**From:** Matthew Woodward  
**Sent:** 18 December 2018 10:20  
**To:** DCAdmin  
**Subject:** FW: 2017/92568 Land off Woodhead Road Honley

**From:** Joe Robertson  
**Sent:** 17 December 2018 14:27  
**To:** Matthew Woodward <Matthew.Woodward@kirklees.gov.uk>  
**Subject:** 2017/92568 Land off Woodhead Road Honley

There is still no Arboricultural Method Statement, despite asking for it in my comments in August 2017, this requirement has also been flagged up twice since then. The Arboricultural Impact Assessment that has now been provided was signed/completed on the 4<sup>th</sup> Decembers 2018.

Indicative Drainage Layout / Storage Calculations

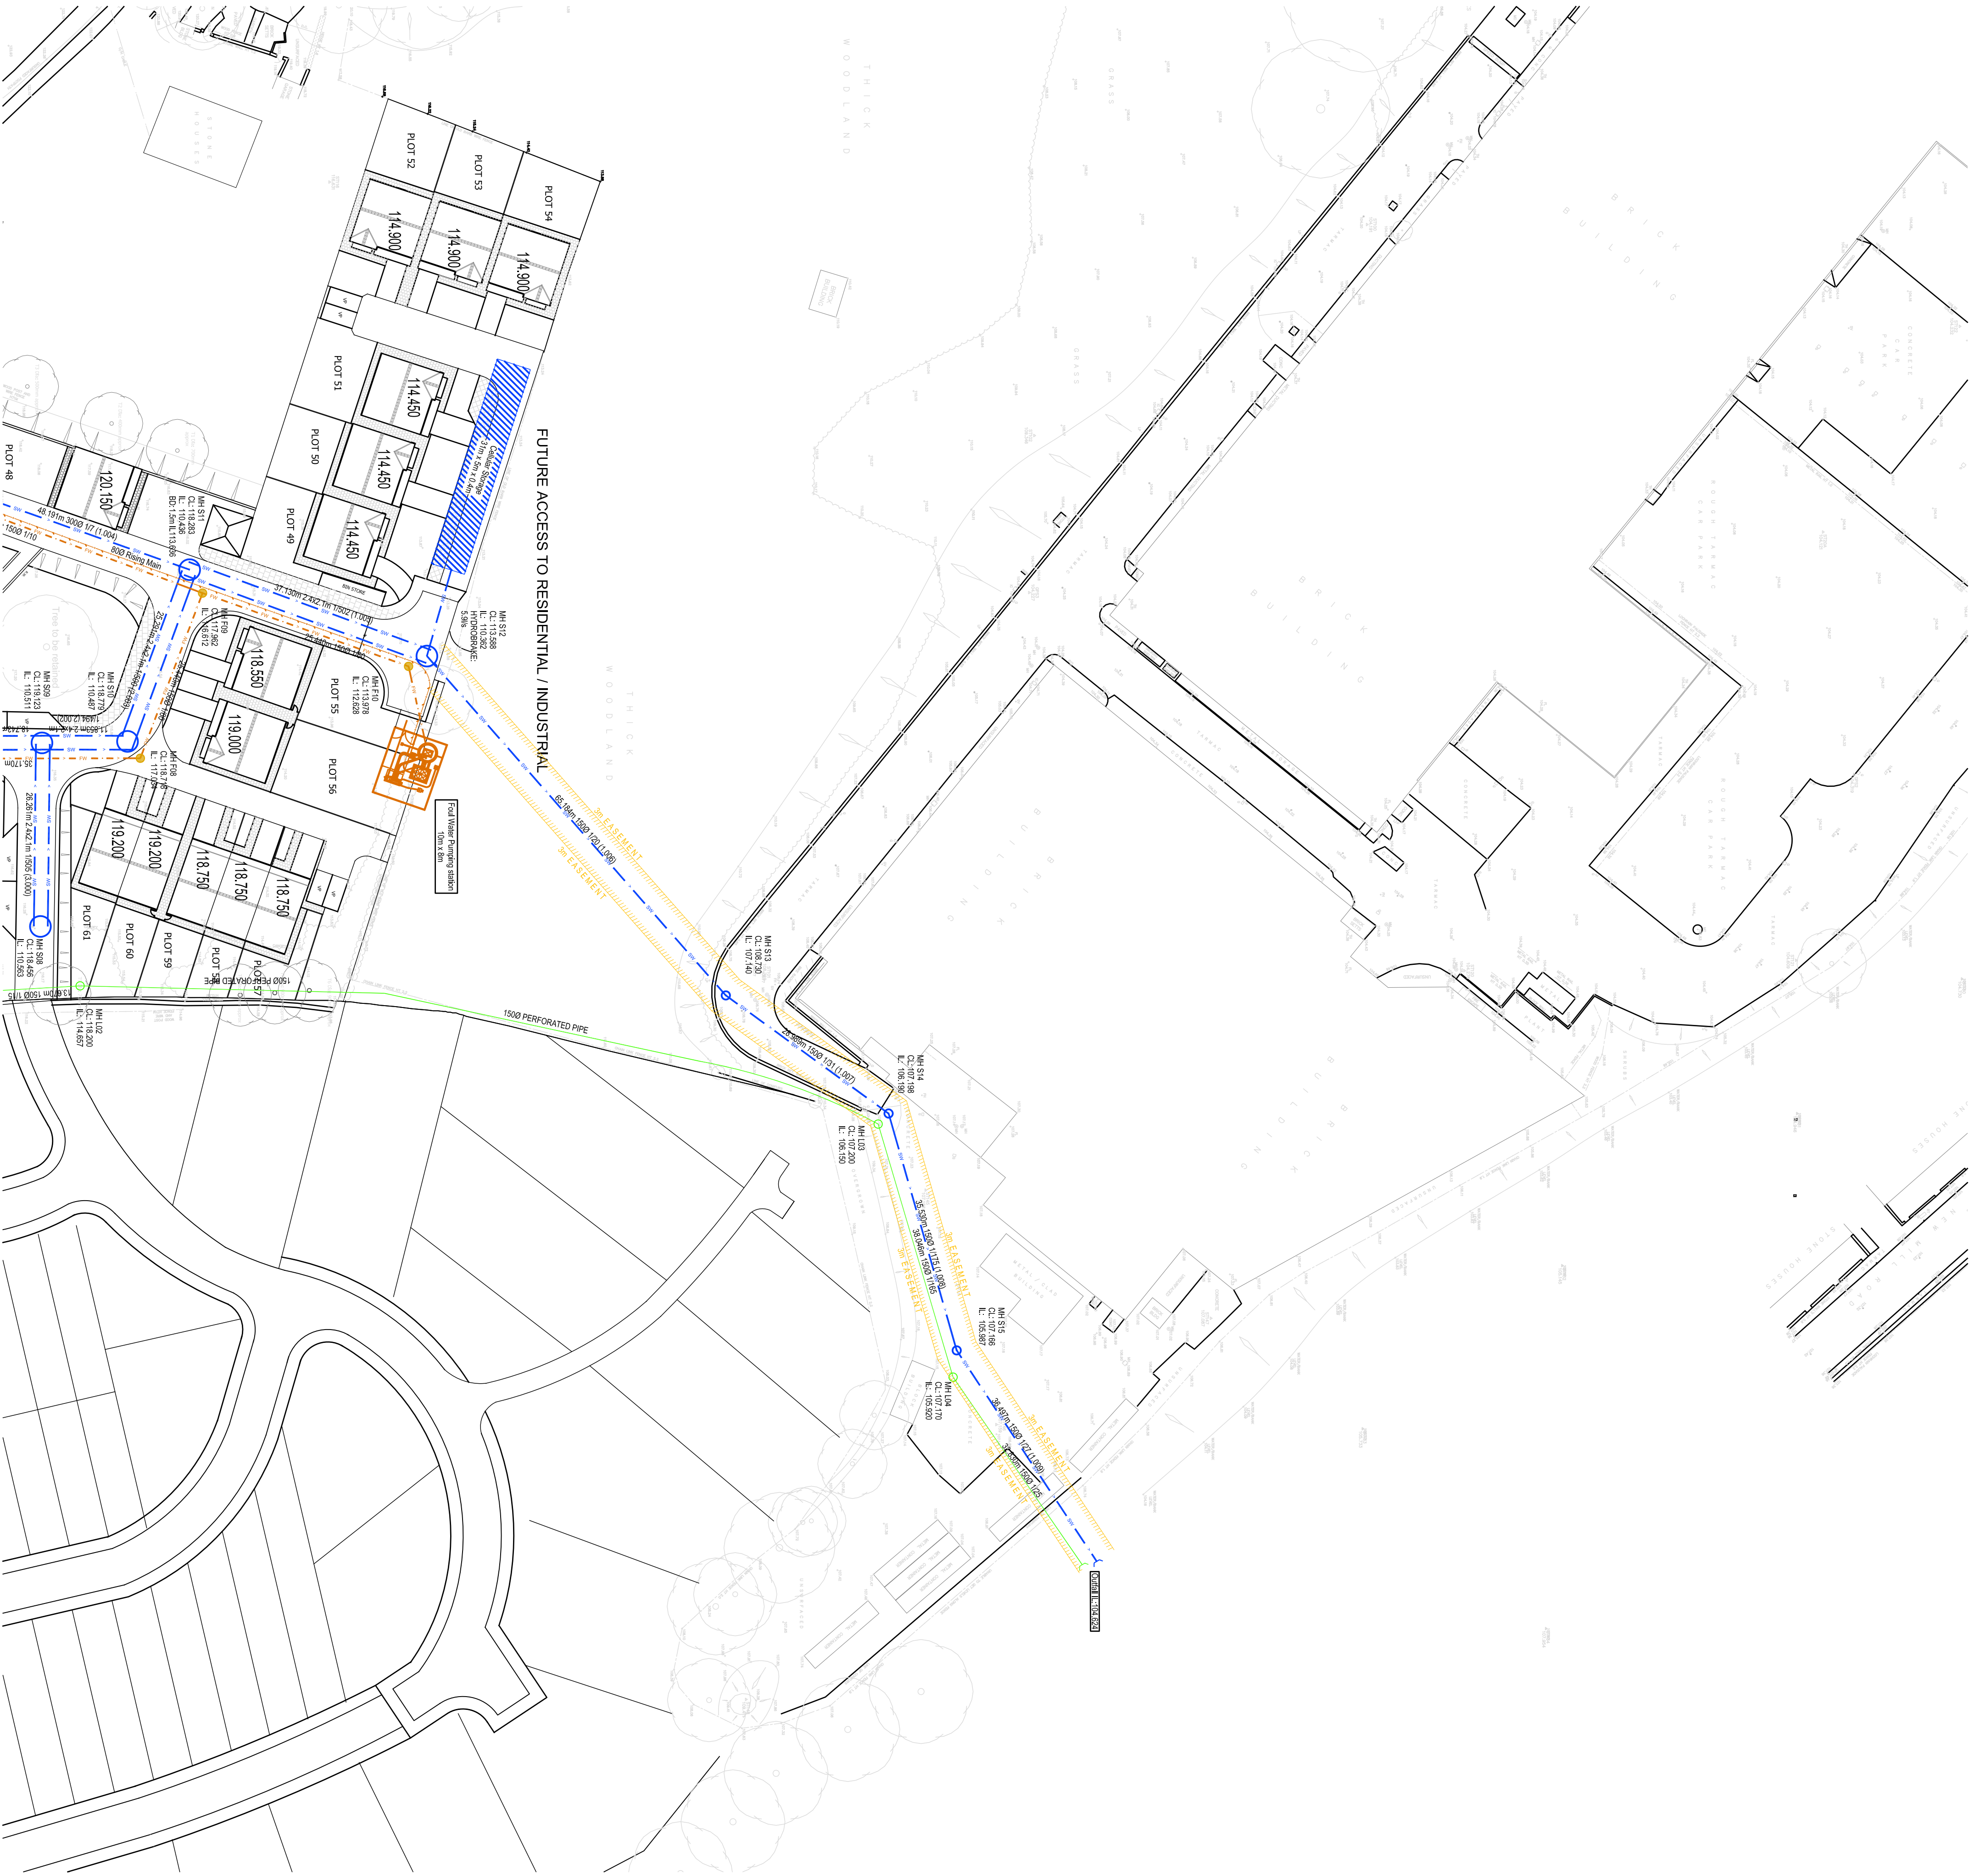
1. There's no information provided in the Impact Assessment with regards to the pumping station shown on the plan, specifically its construction, required excavation, where is it pumping to, location of associated utilities runs etc
2. In the Impact Assessment that has been provided many of the trees have been given category A-*"high quality trees"*, or category B-*"moderate quality trees"*, as set out by BS 5837. Given their identified value, there appears to have been insufficient consideration given to these trees as site constraints.
3. plots 55 and 54 will be completely dominated by trees and their location is unacceptable
4. plot 17 and 18 will experience shade issue, with 18's garden having a large section covered by overhanging branches.
